Recommendation Report for Planning Permission for Works or Extension to a Dwelling

REF NO: R/4/19/HH

LOCATION: 32 Mill Lane
Rustington
BN16 3JN

PROPOSAL: Front and rear single storey extensions and dormers to front and rear roof slopes.

PROPOSED GROUND FLOOR
1:50

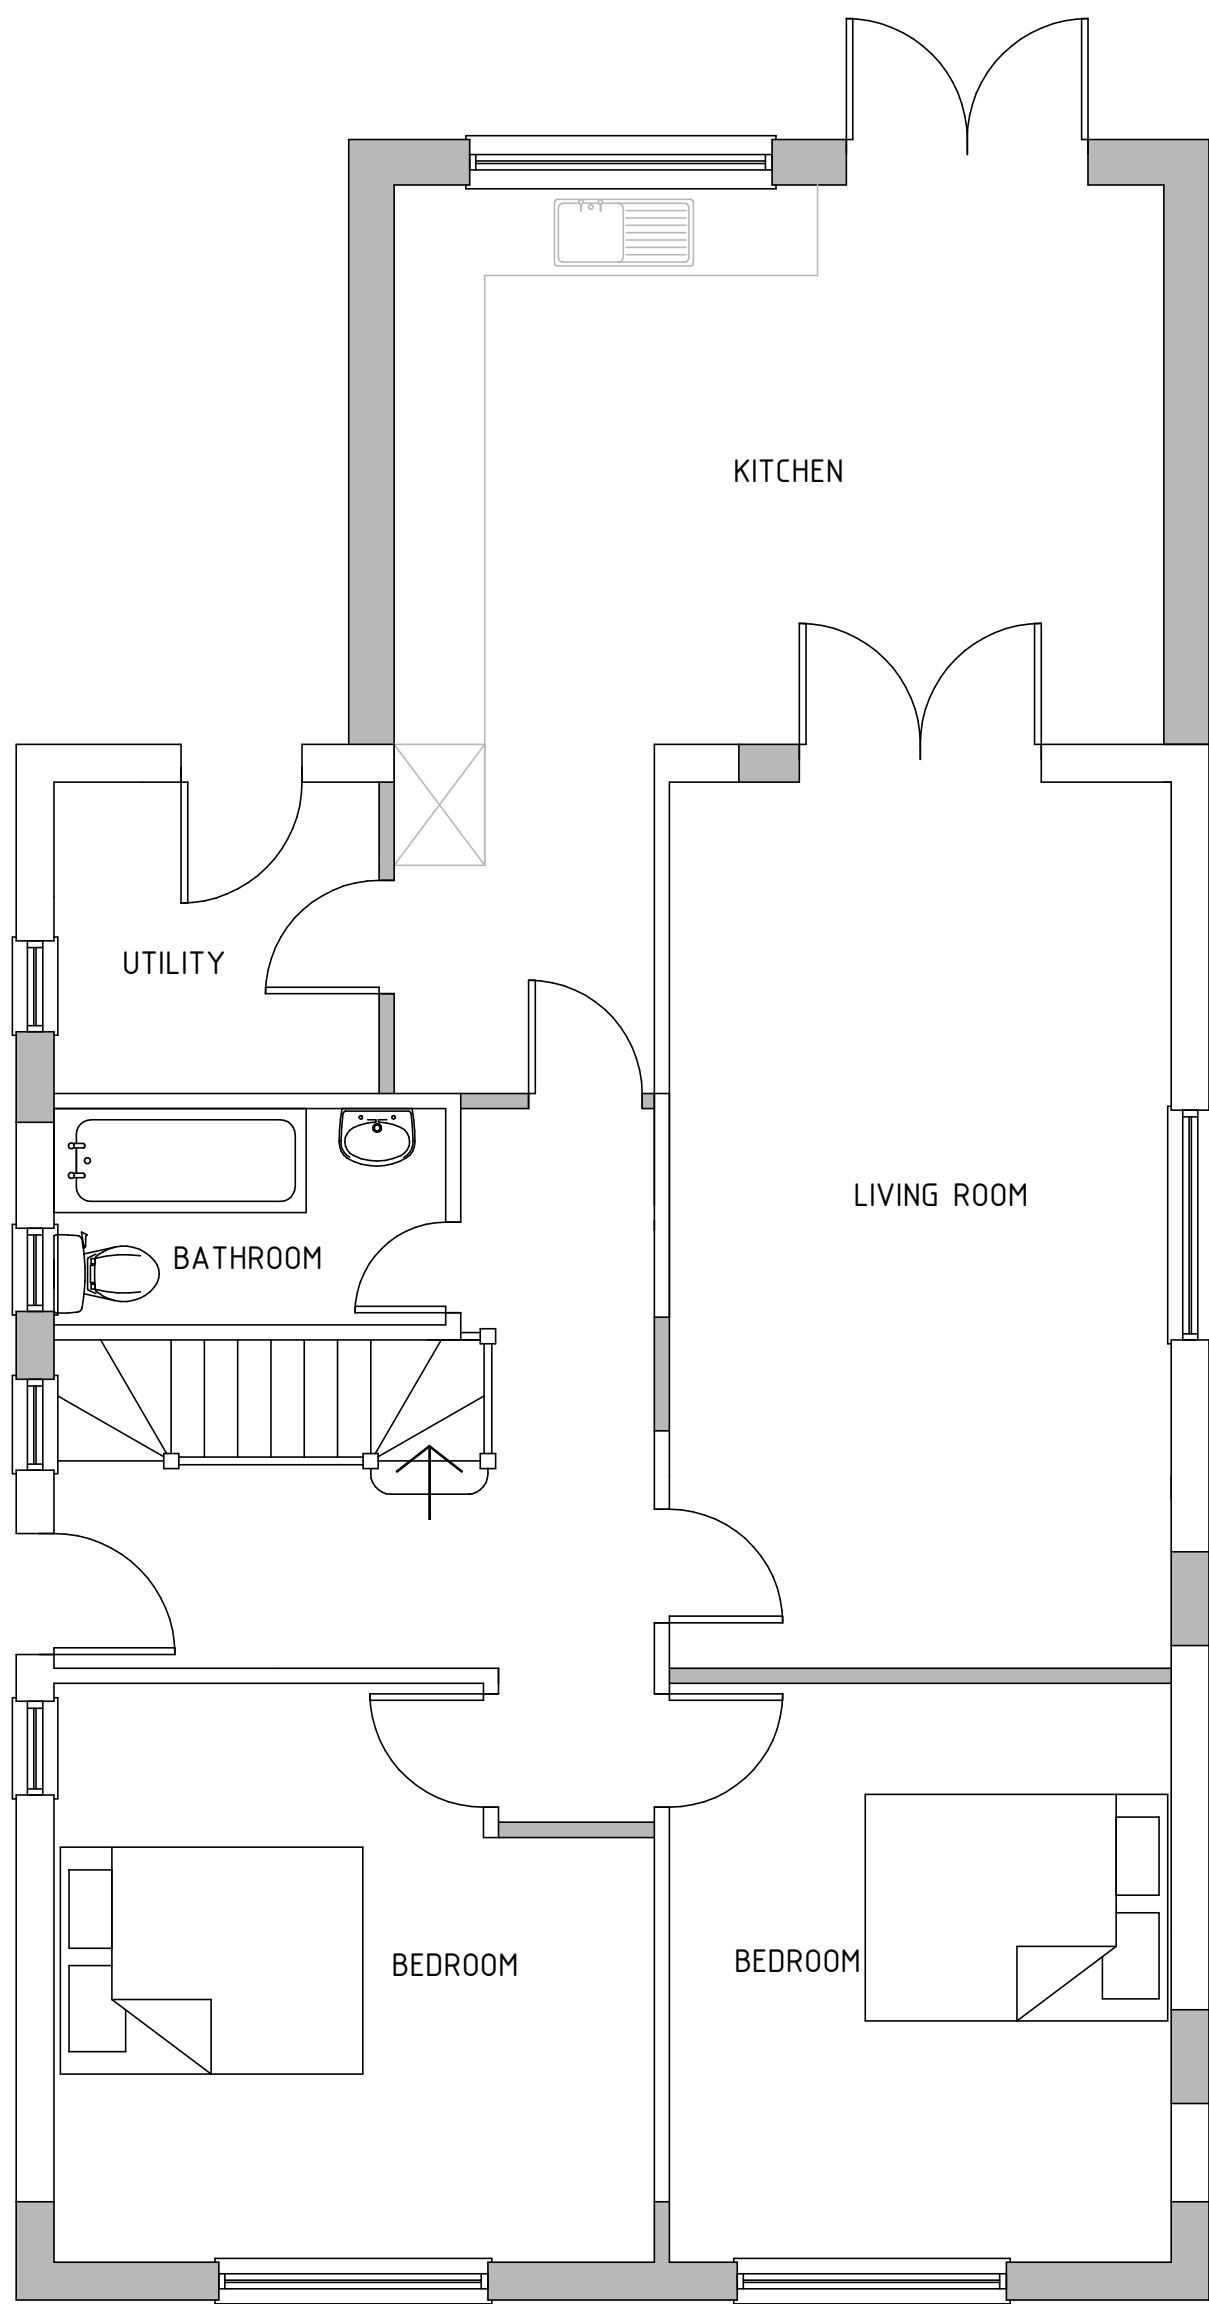
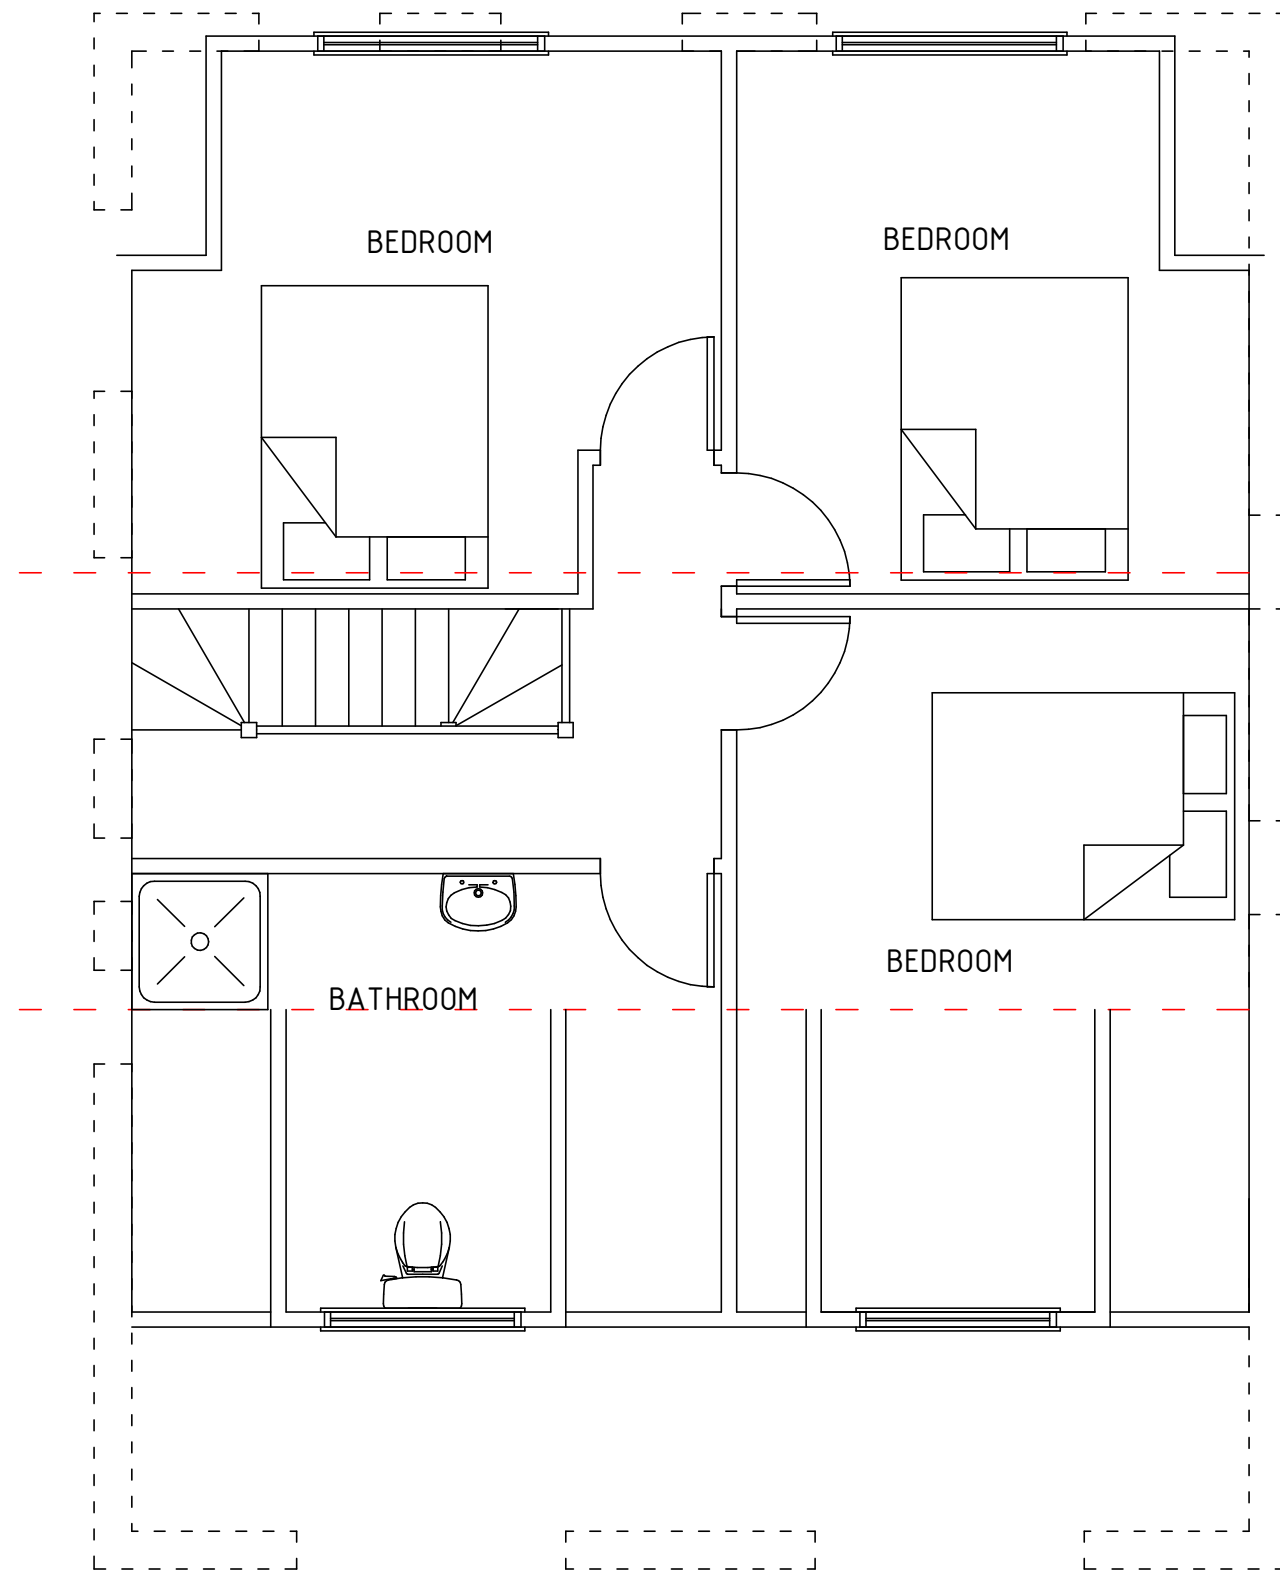
The proposed alteration to the front of the host dwelling, whilst it is considered to comprise of a change in appearance to the front of the host dwelling, it is not considered to have a significantly detrimental impact upon the character of the host dwelling. This is as a result of its modest scale allowing the proposal to not appear as a prominent and obtrusive feature. It re-sites the access door to the Northern elevation of the host dwelling, and alters the front of the dwelling to have a single continuous front elevation, as it brings the whole elevation in line with the existing bay window.

As a result of the siting and location of the single storey rear extension, there are no available views from the street scene, and therefore, it has no significant impact on the street scene, or the established character of the locality. Resultant of the proposal materials and the modest scale of the proposed development, it is considered that the proposal is subservient and sympathetic to the host dwelling, and is therefore in accordance with D DM1, D DM4(a) and (b) of the Arun Local Plan.

As a result of the siting, scale and design of the proposed rear extension, it is not considered that there is any significantly harmful impact upon the residential amenities of neighbouring dwellings.

PROPOSED ROOF PLAN
1:100

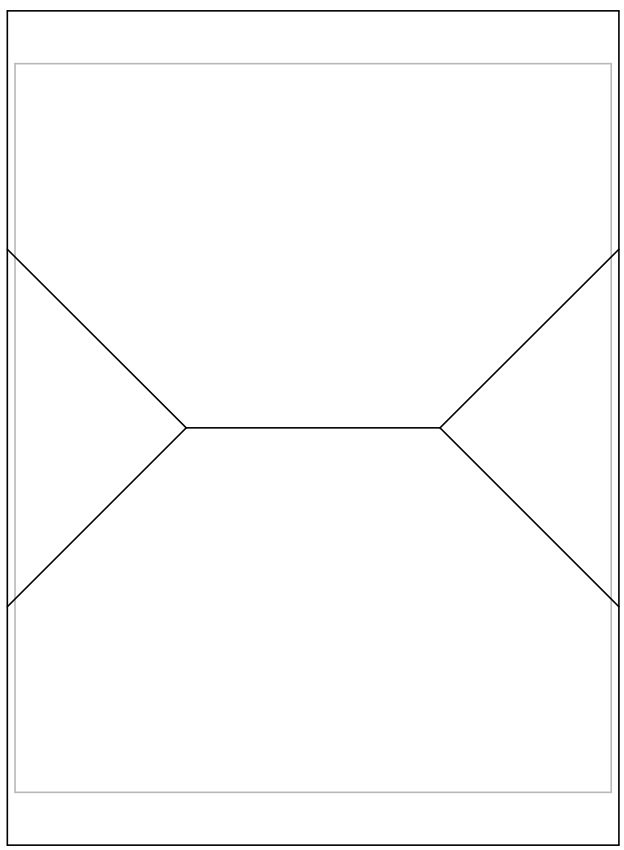
The proposed front dormers are visible within the street scene, however, they are considered to be an improvement to the appearance of host dwelling. They are considered to be sympathetic in design and well integrated with the host dwelling. Their maximum height is 0.5m lower than the maximum ridge height of the host dwelling, and they are sited more than 1m from the Western and Eastern ends of the dwelling. Therefore, the proposed front dormers are considered to be in accordance with D DM1(2), D DM4(a) and (b) of the Arun Local Plan.

The front dormers that form part of the proposal are considered to be acceptable in terms of neighbouring residential amenity. This is resultant of their modest design and siting at the front of the dwelling, allowing there to be no unacceptably adverse overshadowing or overbearing impacts on adjacent occupiers. Additionally, resultant of the siting, any views available are of the street scene.

PROPOSED REAR ELEVATION
1:100

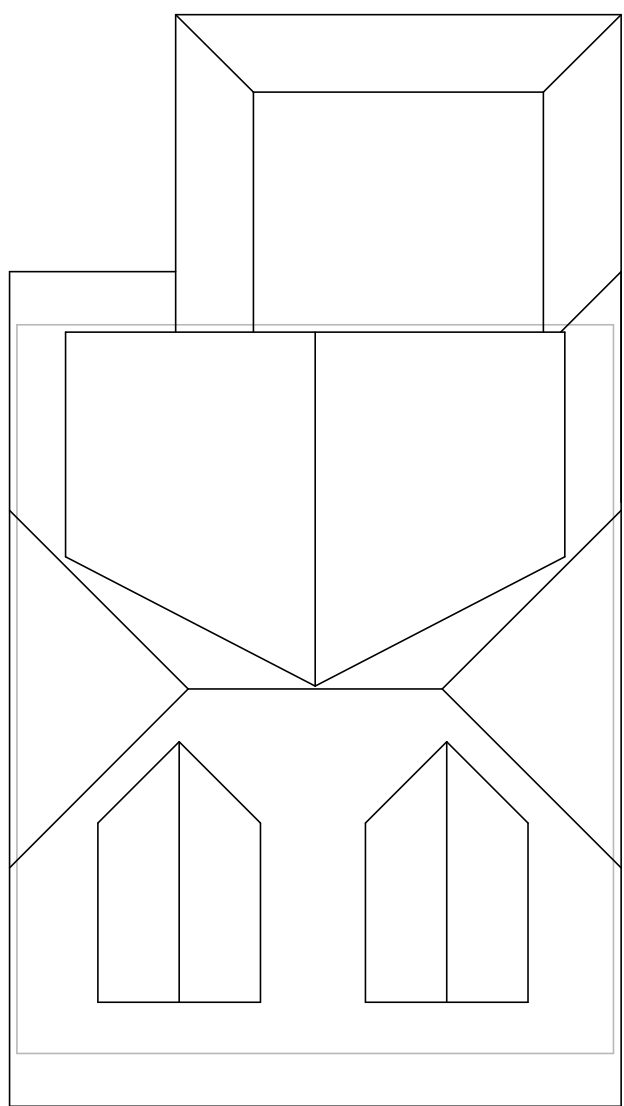
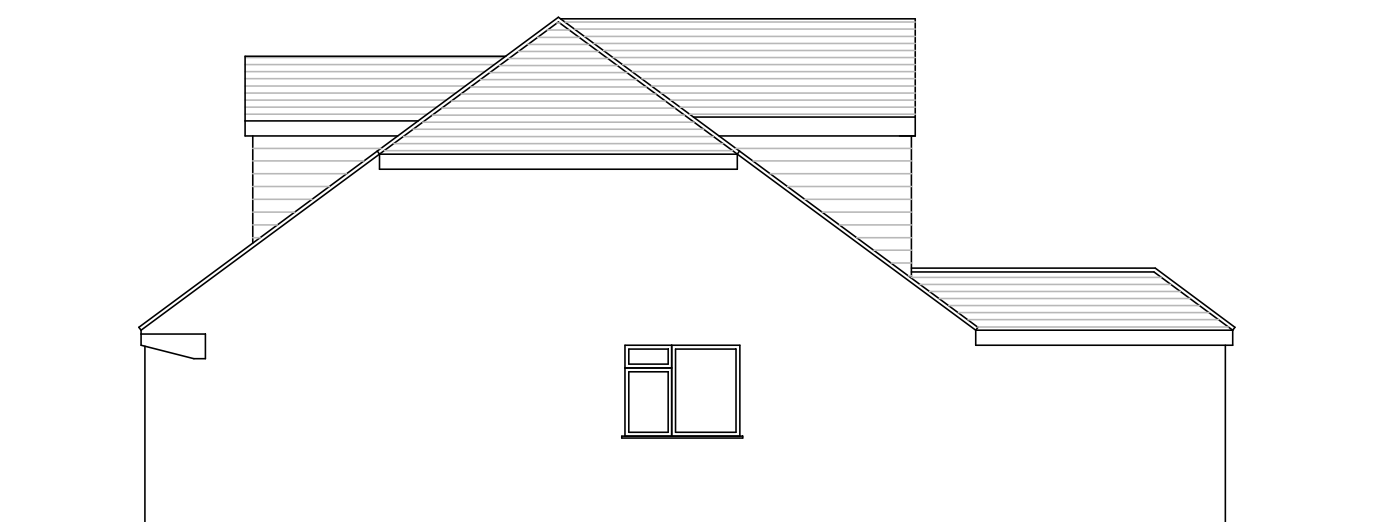
- The large rear dormer will overlook properties to the rear on Fircroft Crescent.

The rear dormer is not considered to have any significant overbearing or overshadowing impact as a result of the proposal all being retained within the same footprint as the host dwelling. The proposal extends the host dwelling at ridge height level by 4.6m, however, this is not considered to overshadow the dwelling to the North, as a result of the siting of the garages, a separation distance of over 5m. With regard to overlooking, the windows of the dormer are approximately 15m from the rear of the site, and over 40m to the rear of adjacent dwellings to the East. Additionally, it is likely that a dormer of a similar design could be constructed under Permitted Development.
